Your Ref :
Our Ref : FG/102/14/NMA

Section 96A of the Town & Country Planning Act 1990 (as amended)
Town and Country Planning (Development Management Procedure) (England) Order 2010 (as amended) - Article 9

Application for a non material amendment following a grant of planning permission FG/143/12/ for a third velux rooflight to east elevation of front extension rather than west elevation, extra window to west elevation of front extension and extra rooflight to rear elevation.
2 Ferringham Lane, Ferring, ,

2 FERRINGHAM LANE, FERRING
Proposals 10 £ Oct 2012

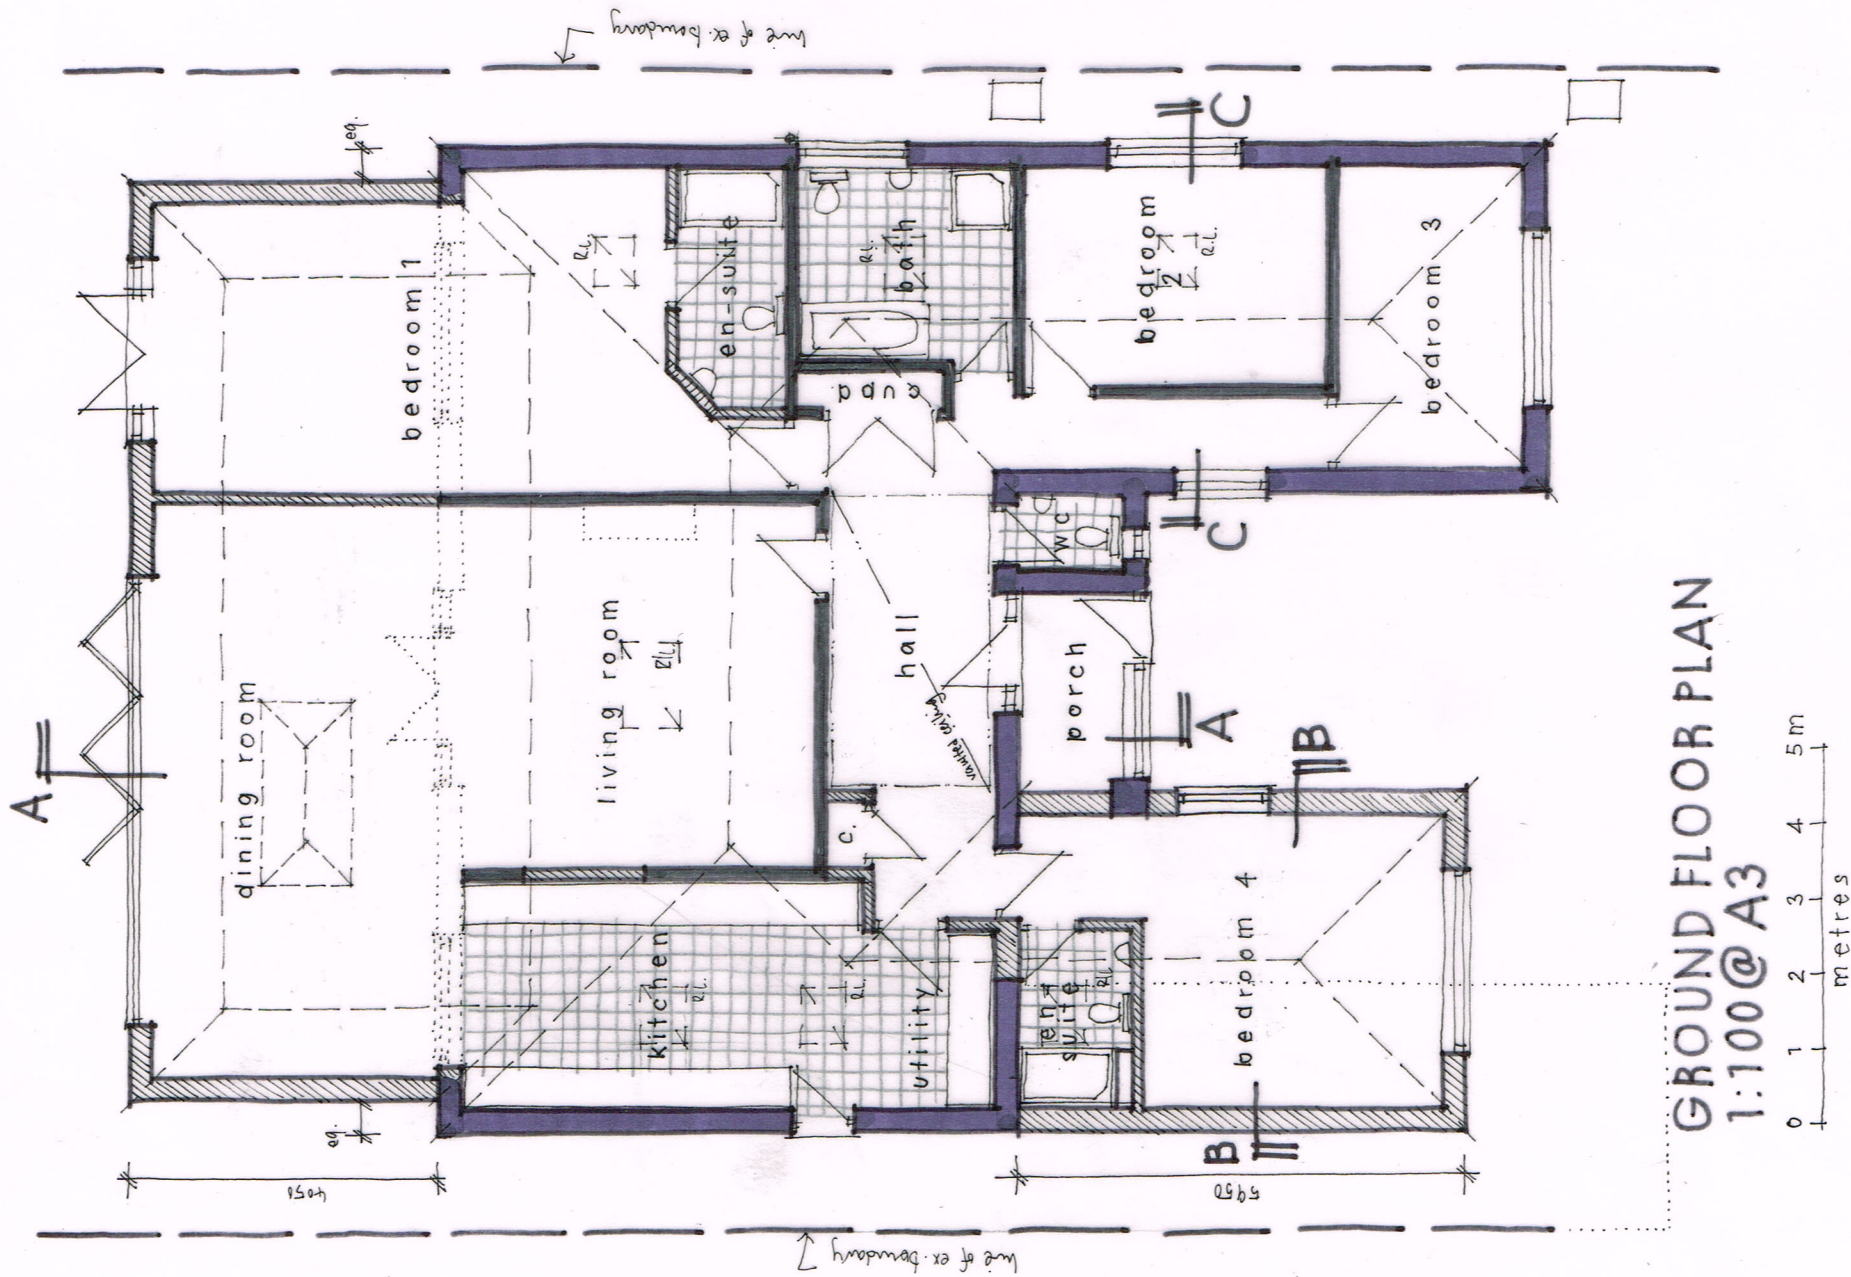
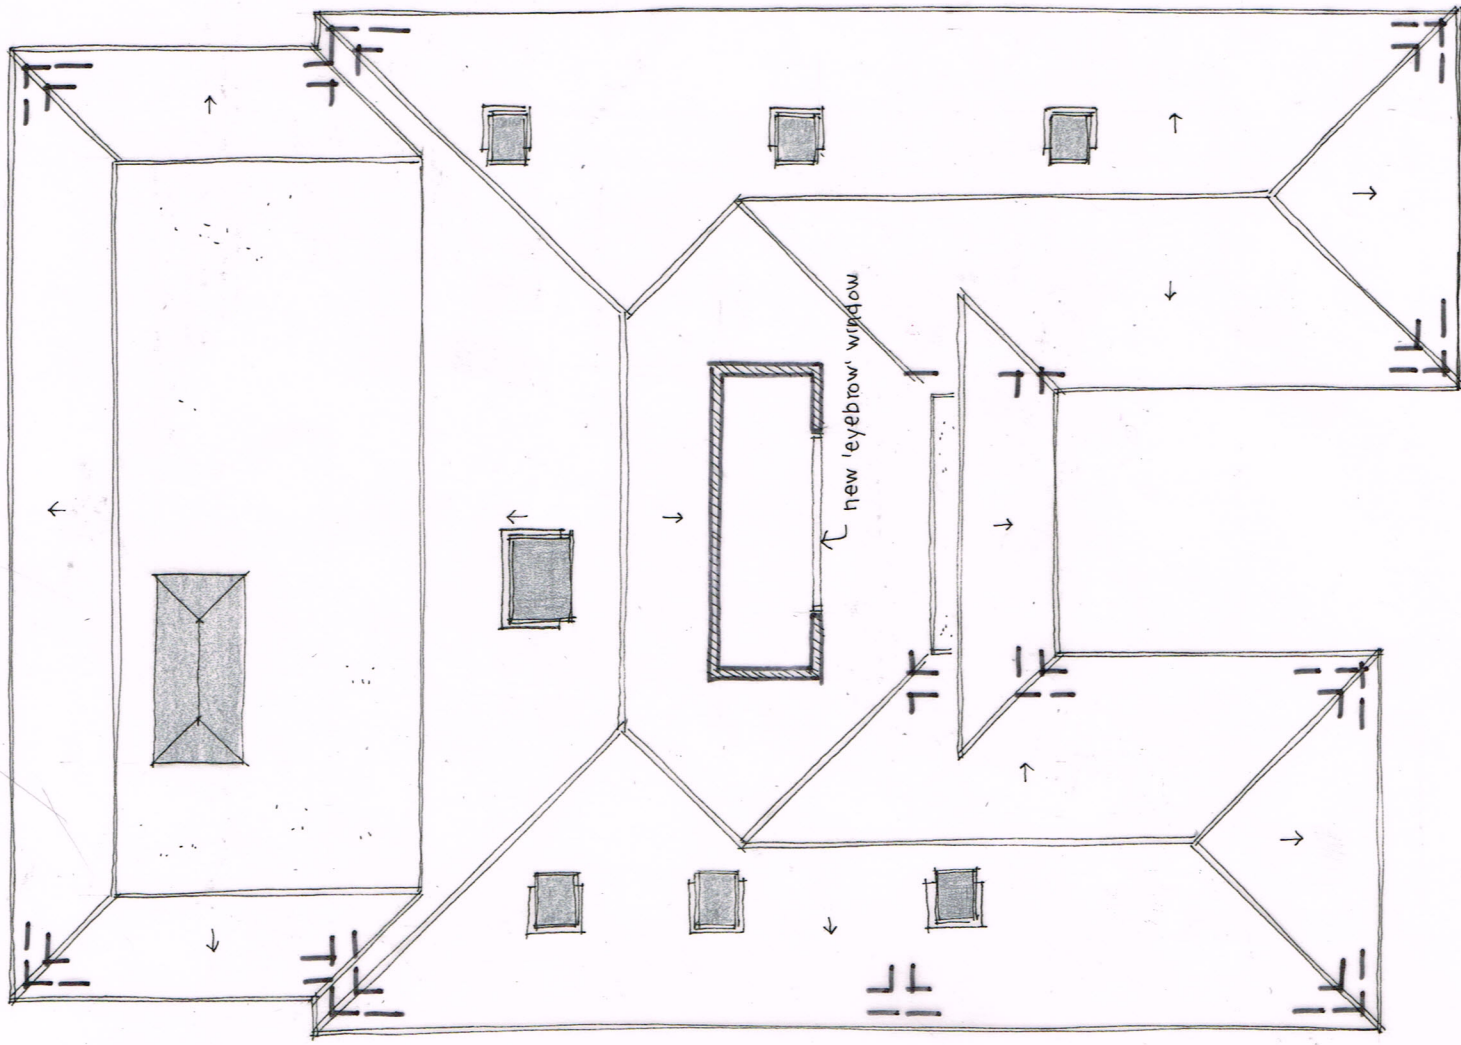
I refer to your recent application for a Non Material Minor Amendment. From the information submitted I can confirm that the proposed amendments to the scheme, namely the introduction of an additional roof light to eastern roof slope of the approved extension to the front of the dwelling and a new roof light to rear roof slope can be accepted as a non-material minor amendment.

Please note the following plans now form the approved plans for FG/143/12; 'Proposals 10 B' and 'Proposals 11 B'.
